**Cotefield Farm, Oxford Road, Bodicote,  
Oxfordshire, OX15 4AQ**

**22/01587/NMA**

**Proposal:** Tint the bricks in the under build so they match the stonework above, additional planting to screen the tinted brickwork, amend landscaping plan numbered '1908 15 J' with '1908 15 L' and variation of condition 1 to amend the list of approved plans (proposed as non-material amendments to 18/01309/REM)

Site:	BODICOTE		
House Type:	RADLEY	Unit Size:	147.1m ² 1583.3ft ²
Drg Title:	BLOCK PLANS - PLOT 91		
Scale:	1:50 (Foundations)	Page Size:	A2
	1:100 (Elevations)	Drawn:	MK
		Date:	MAY 22
		Checked:	-
Drawing No:	14752/HMA/RADLEY/691-PD		Revision: P1

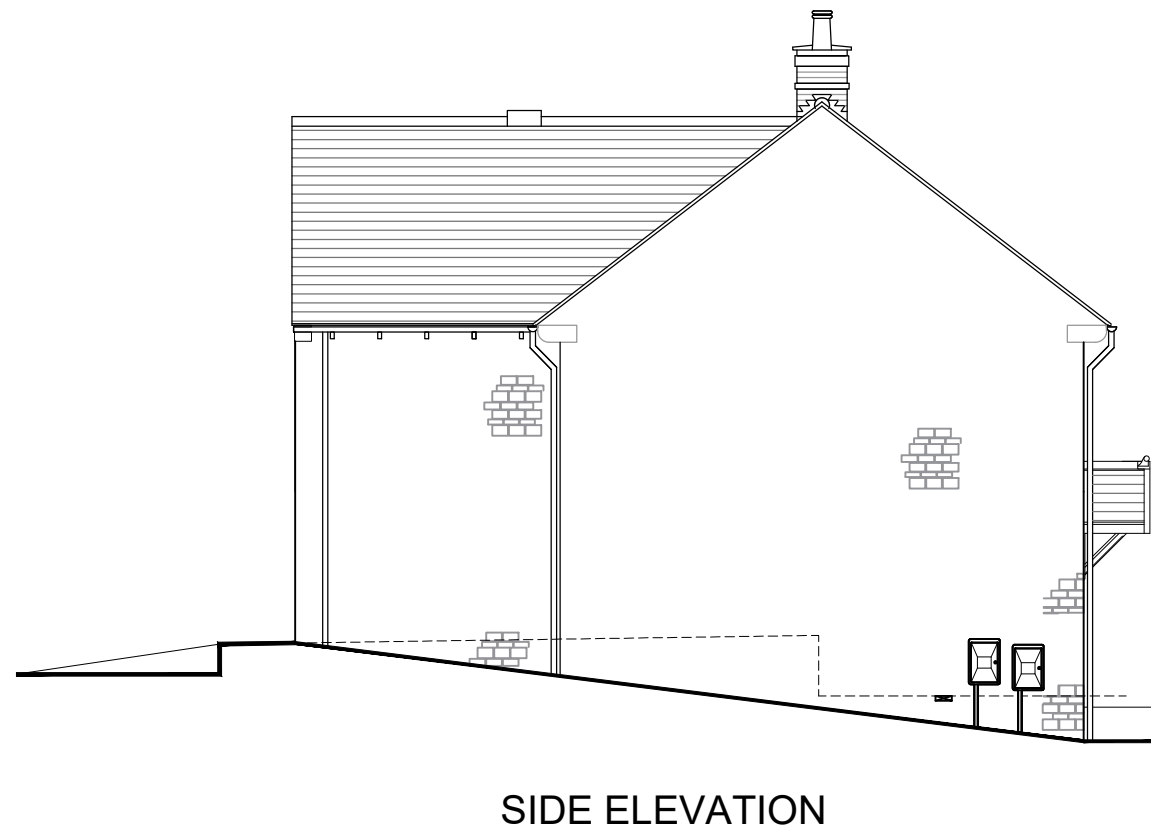
- 5.4. The two plots covered by this application were approved to be finished in ironstone from ground level. As built, red brick has been used from ground level to damp proof course and due to the slope on the site, the extent of brickwork can exceed 1m in height in places. While this situation affects only 2 plots on the scheme and these plots are a significant distance into the development, they front a public open space and are readily visible from this area and from different directions. This change in material is apparent from the public realm and has an adverse effect on the visual amenity of the locality.

- 5.5. The proposed tinting significantly reduces the contrast in colour between the brick and the stone, though it does not change the size and shape of the brickwork which still differs from the stonework. The change in colour as a result of the tinting would significantly soften the effect of the change in materials when both plots are viewed in the wider street scene, though at close quarters the different size and shape of the brick compared to the stone would remain apparent. The additional planting is therefore important in helping to further screen this change and its effects.

- 5.6. As built, Officers consider that the change in material below damp proof course level would result in a material change to the scheme, given the significant contrast between the materials and the visibility from the public realm. However, once tinted, this contrast is reduced and this is further aided by the additional planting proposed. As such, and subject to the additional planting, on a very fine balance Officers consider this change to be non-material.

- 2.1. To address the difference in materials between the stone above damp proof course level and the brick below, it is proposed to tint the brickwork to bring its colour closer to that of the stone work. It is also proposed to add additional planting to screen the brickwork.
